**Application by Cory Riverside Energy for the Riverside Energy Park**  
**The Examining Authority's written questions and requests for information (ExQ1)**  
**Issued on [date]**

**ExQ1: [Date]****Responses due by Deadline 2: 20 May 2019**

RIVERSIDE ENERGY PARK
Sound Survey Locations

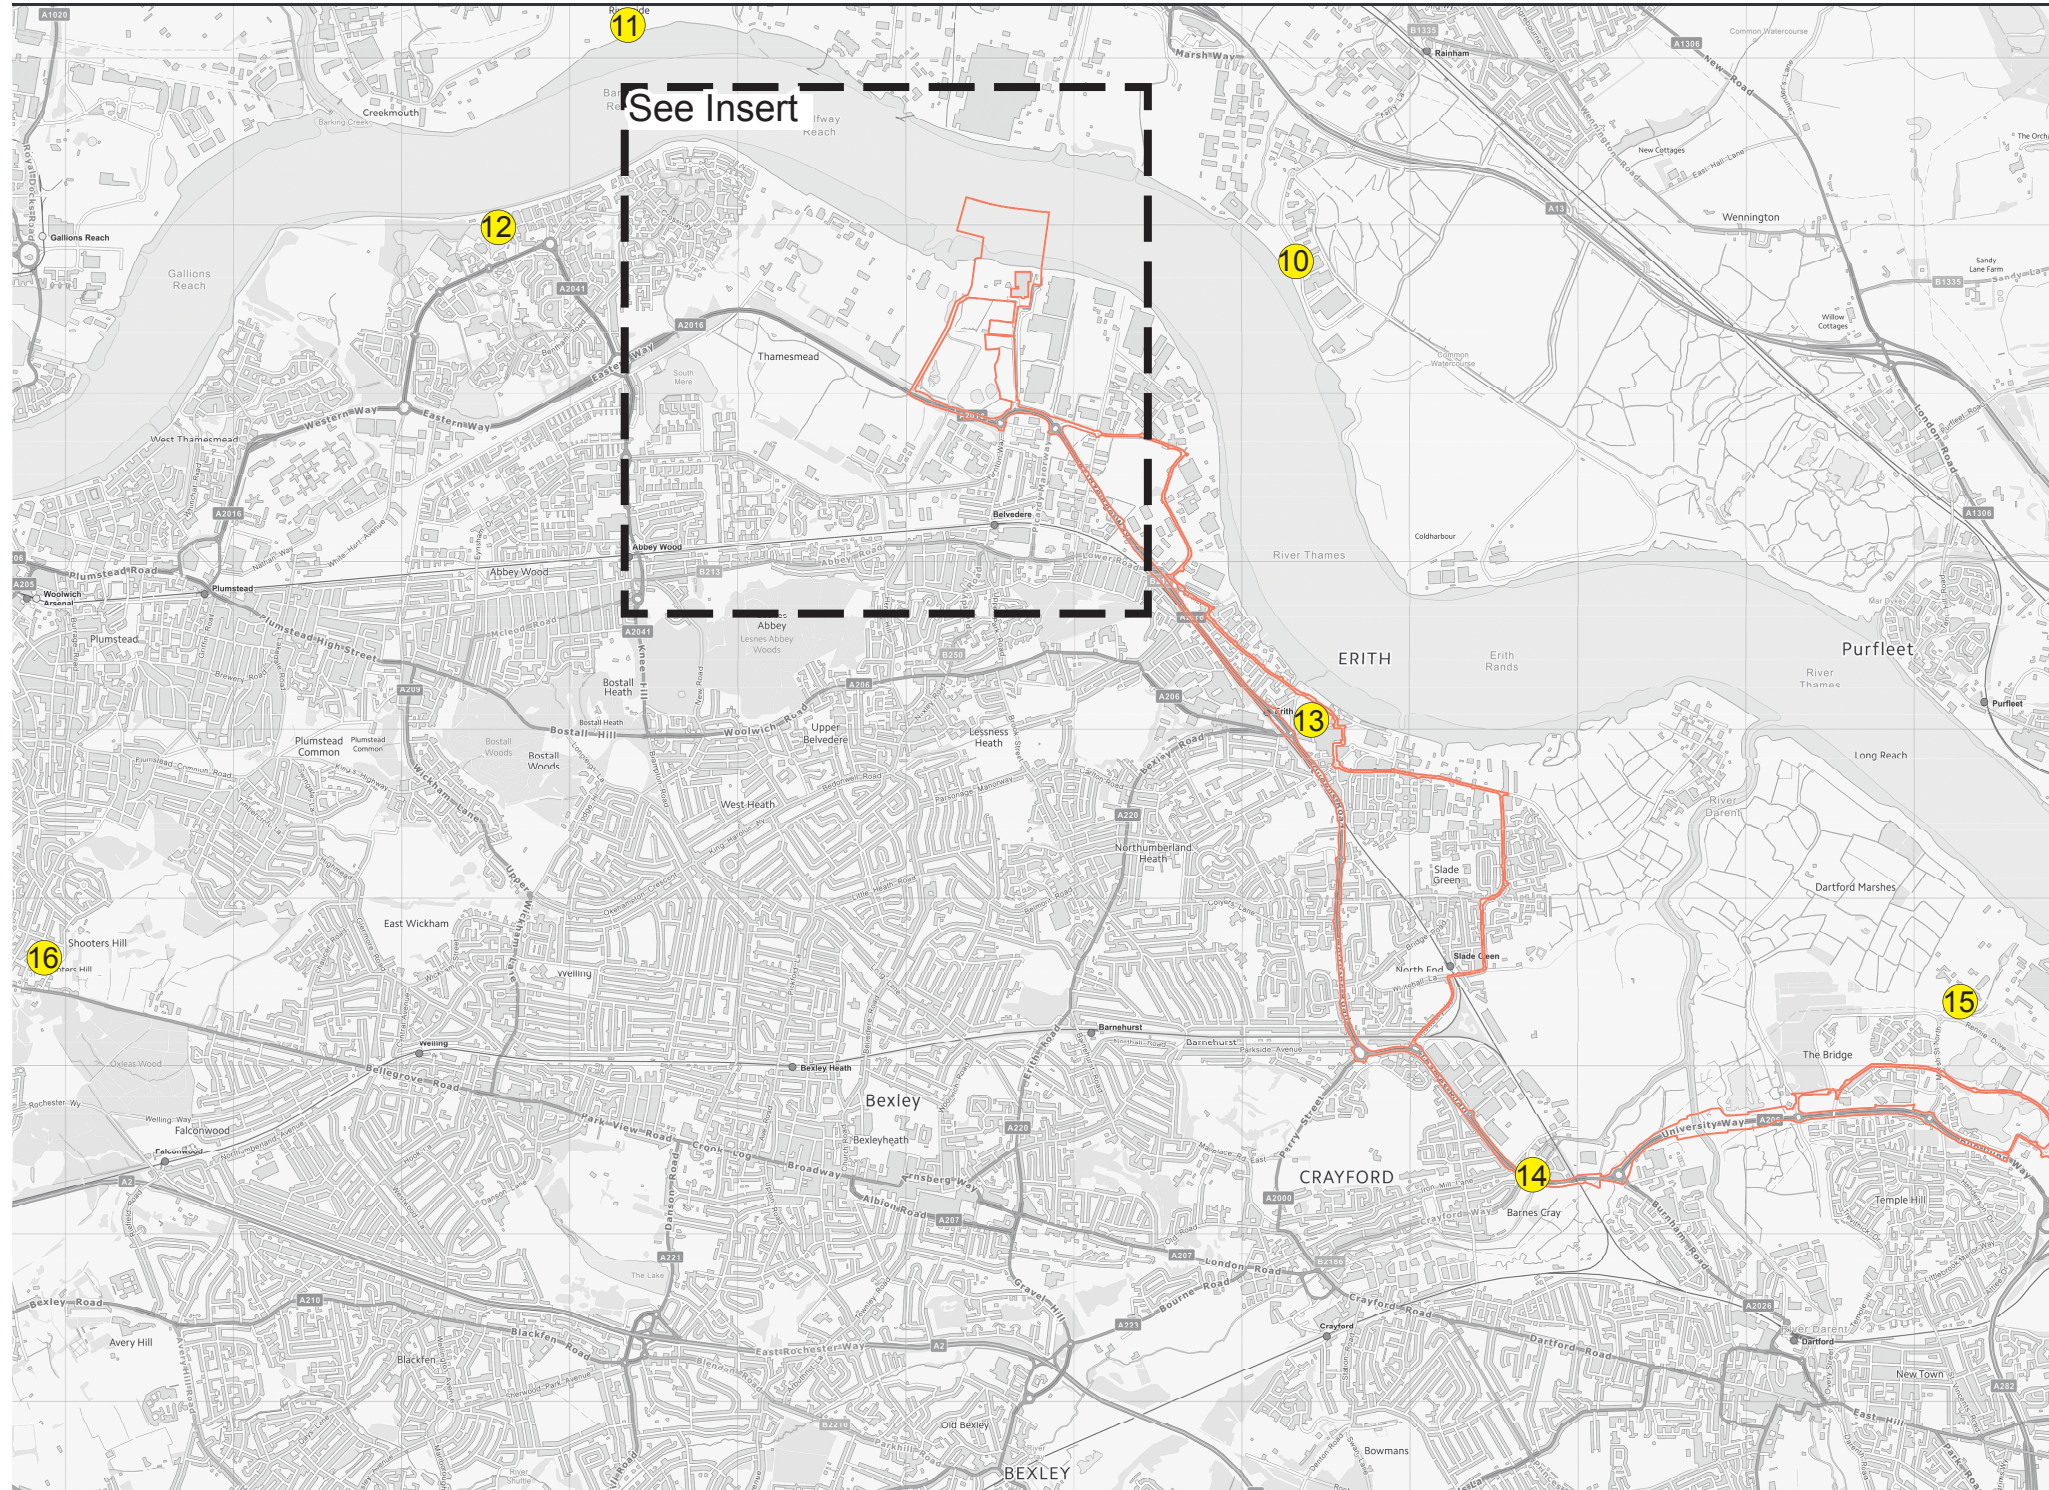
Q3.0.9	The Applicant	Table 11.7 in the ES states that baseline noise levels recorded at location 3 represent levels at Crossness LNR. This location is not clearly identifiable from the noise plan. Please will the Applicant identify location 3.
Q3.0.10	The Applicant	Paragraph 11.9.11 of the ES states that there may be displacement of breeding/wintering birds during construction but that the impact of this is not significant. Please identify the criteria and the evidence that have been used in reaching this conclusion.
